WEST SUSSEX COUNTY COUNCIL CONSULTATION

TO:	Arun District Council FAO: Michael Eastham
FROM:	Stephen Gee WSCC - Highways Authority
DATE:	21 November 2019
LOCATION:	Bexstone House Barnham Road Chichester PO20 3RT
SUBJECT:	BN/65/19/OUT Outline application with some matters reserved for the demolition of existing dwelling & erection of 10 No. new dwellings, widening & reprofiling of site access, provision of a right turn lane with improved visibility splays, retention of significant landscaped highway buffer, parking for 30 No. cars including garages & visitor parking & potential future highway access to adjacent housing land (resubmission following EG/49/18/OUT). Revised app form and amended layout plan.
DATE OF SITE VISIT:	-
RECOMMENDATION:	Objection / More Information
S106 CONTRIBUTION TOTAL:	-

Designers Response demonstrating moved Island /

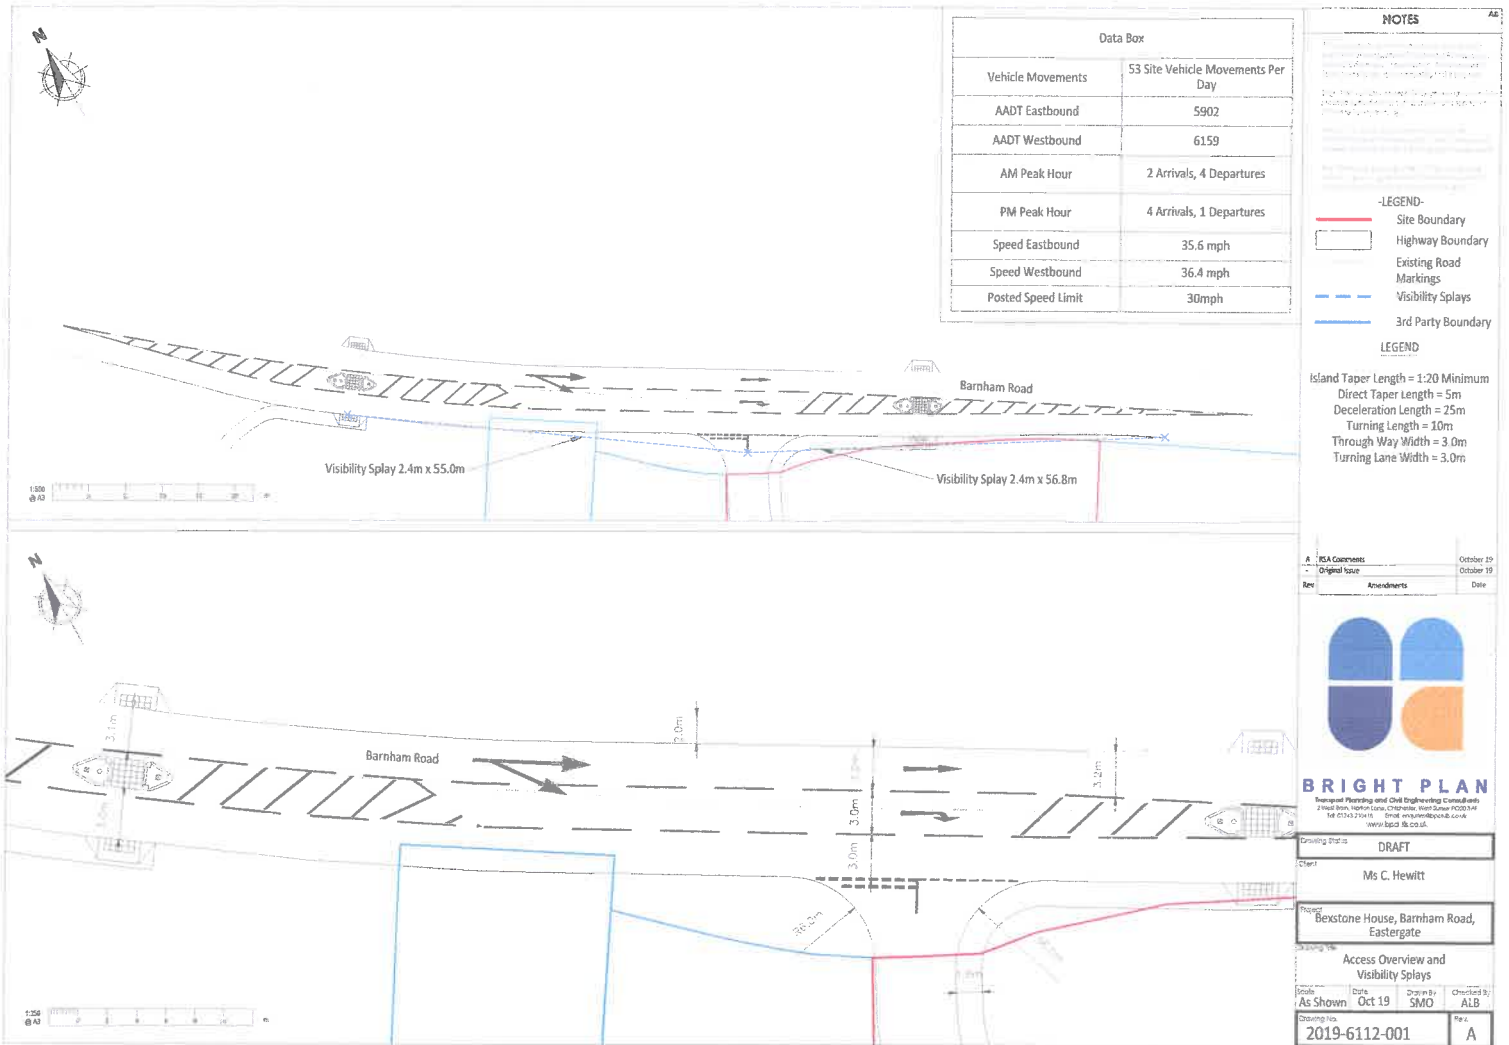
- The provision of a right hand turn ghost lane for the provision of 10 dwellings would not be required. In line with DMRB guidance a right hand ghost island should be considered if the AADT of the minor arm is above 300 daily movements. At present there is no guarantee that additional development would be served via the proposed access and if a right hand turn Ghost Island is required. As identified in my previous response Arun District Council should consider whether the site accords with Policy H SP2 (Strategic Site Allocations) of the Arun Local Plan; in that the policy requires the sites to be comprehensively planned and that they should have regard to an endorsed masterplan.

- The Stage 1 RSA and designers response that has been undertaken should be formally provided.
- Vehicle tacking has been provided directly to me which shows a refuse vehicle crossing the centre line when accessing and egressing from the site access given the application is identifying the potential to serve a wider allocation then concerns are raised. Additionally the internal road network shows a 90 degree bend which raises is likely to raise further concerns with the vehicle tracking.
- Junction Modelling should be provided, the scenarios should be discussed with me and based on the potential trip generation of any sites to be served of the access in accordance with an approved masterplan.
- Consideration of access being sought in conjunction with EG/22/19.
